**RE: Juan Tabo Hills Estates Preliminary Plat, Project # 1005278**

The purpose of this letter is to explain how the comments as contained in the DRB Official Notice of Decision (May 21, 2015) have been addressed. The following items have been revised and are being re-submitted for review and approval.

1. Preliminary Plat (including Sheet 1 Vacation Exhibit),
2. Infrastructure List,
3. Sidewalk Exhibit
4. Perimeter Wall Detail
5. Grading and Drainage Plan

NEW STORM SEWER EASEMENTS

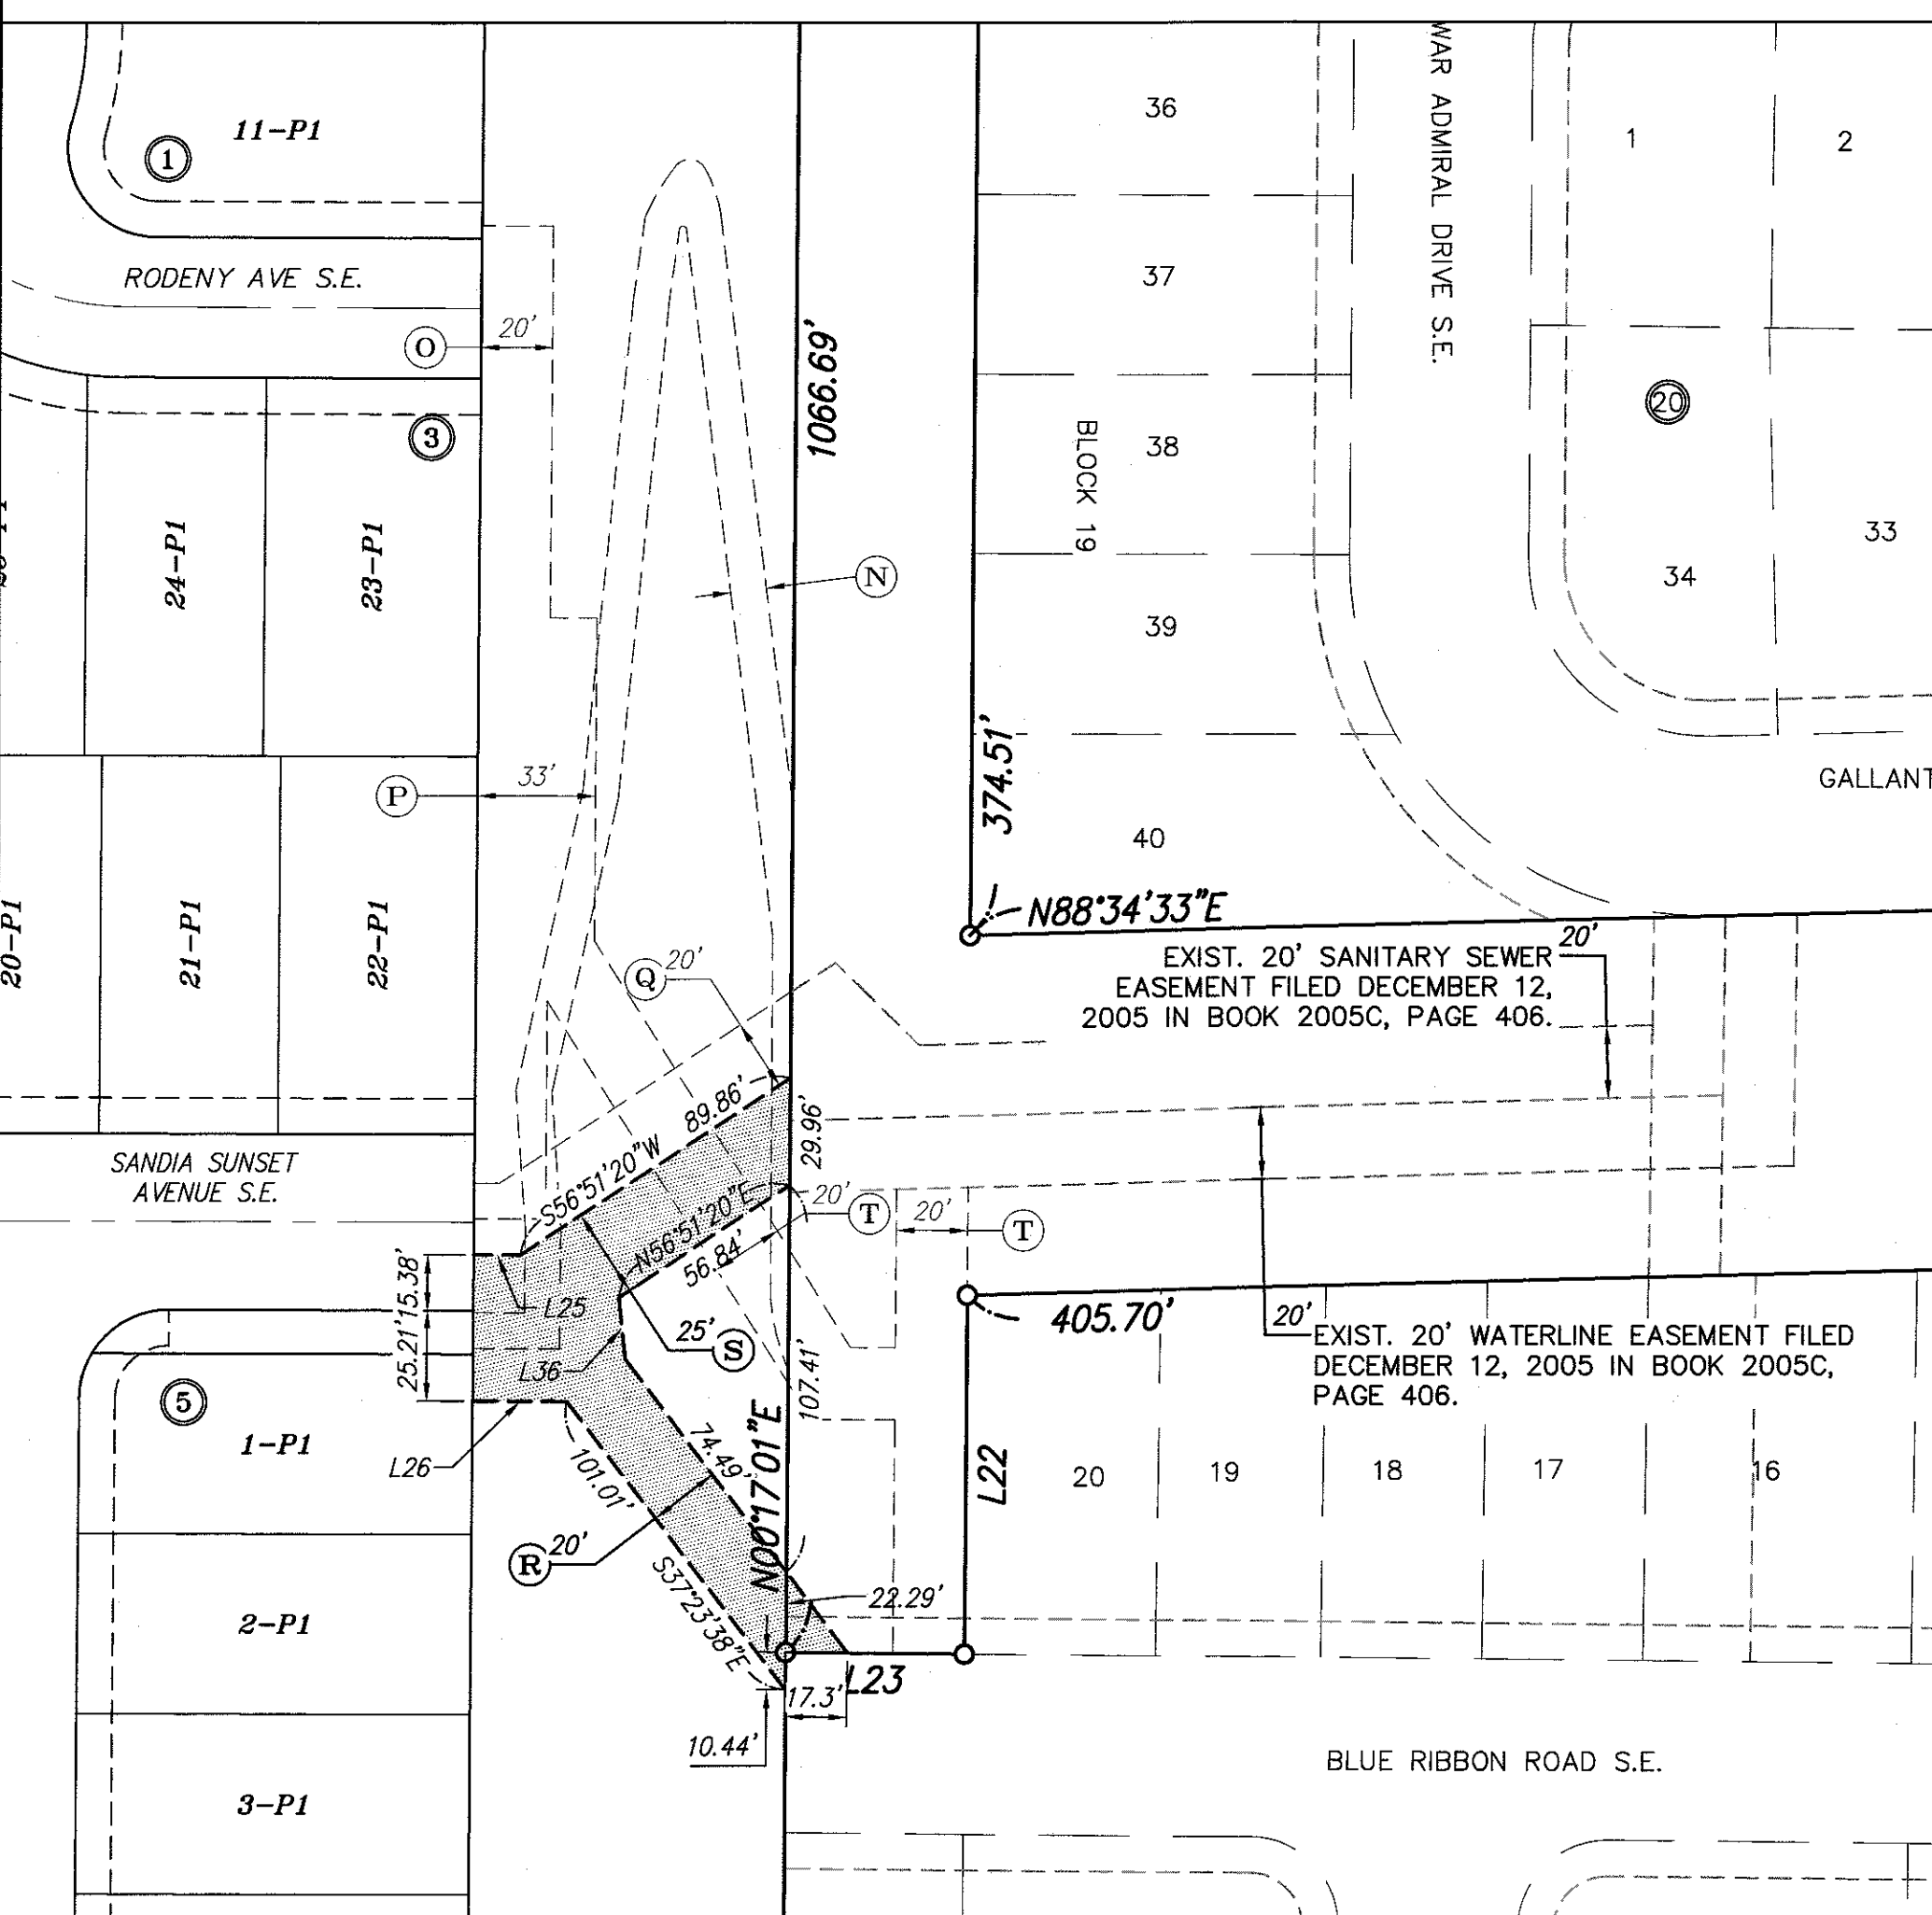
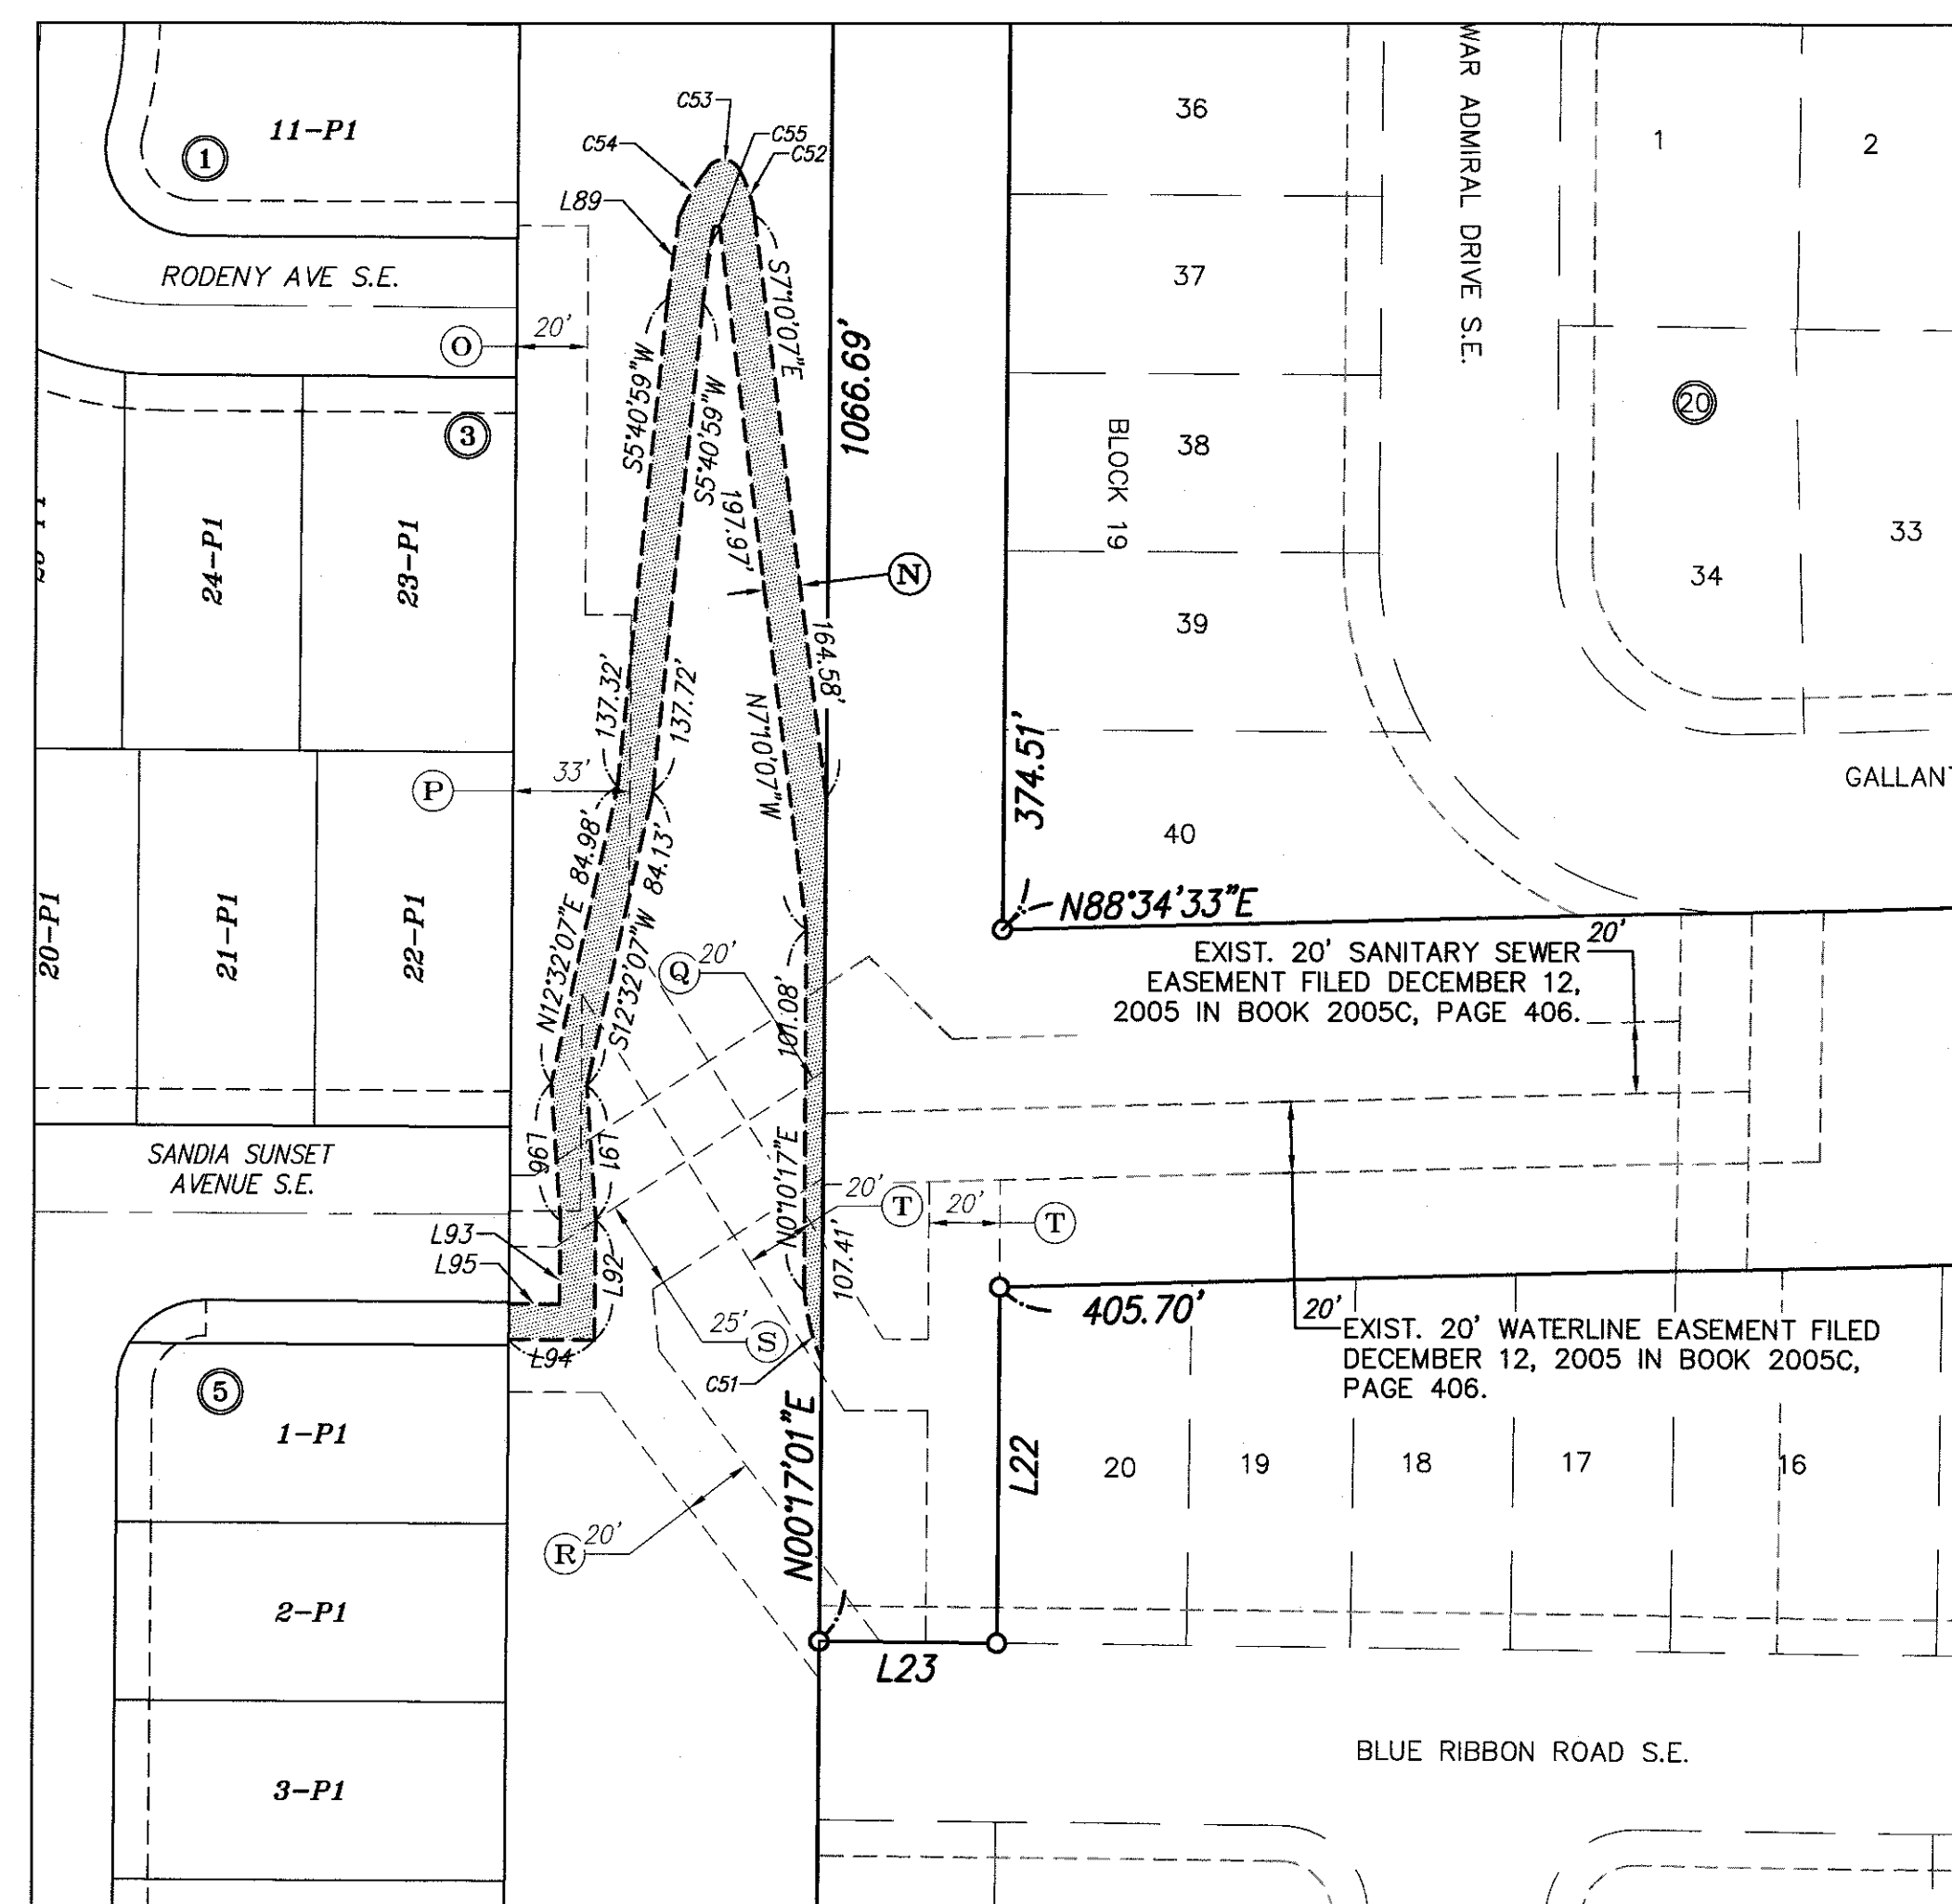
ABCWUA comments (1.) A development agreement has been submitted to ABCWUA for Board approval. It should be introduced to the Board at the October 21 meeting and then hopefully approved at the following meeting on November 18. (2.) Mark Goodwin is not willing to provide an acknowledgement letter. (3.) Site Plan comments are not applicable since the Conceptual Utility sheet has been removed from the Site Plan. However the Conceptual Utility Plan has been updated and provided as an aid to review of the Preliminary Plat and the Infrastructure List. (4.) The Infrastructure List has been revised by (4.i) changing the 8" water lines to 10" in Pocono Rd, Silver Dollar St, Manzano Vista Ave, Rock Squirrel and Sandia Sunset, (4.ii) 8" water line connection added between the existing line in Blue Ribbon Rd and the existing line in Tract 1-A-1-B which connects to Gallant Fox Rd., (4.iii) the 6" waterline in the stub on the south end of Hubbard remained 6" on the infrastructure list and was changed to 6" on the Conceptual Utility Plan, (4.iv) the north end of the Canyon Wren water line was changed to 8", (4.v) the 6" water lines in stub streets were changed to 4" water lines, (4.vi) the White Dove St. water line was changed from 6" to 8", (4.vii) the removal of the existing 21" SAS was added, (4.viii) the removal of the existing 8" SAS in Tract 1-A-1-B was added, and two Pressure Reducing Stations were added to the Infrastructure List. (5.) The Preliminary Plat was revised by adding the Vacation of a portion of Tract D to Sheet 1, and by separating the storm easements from the sanitary and waterline easements.
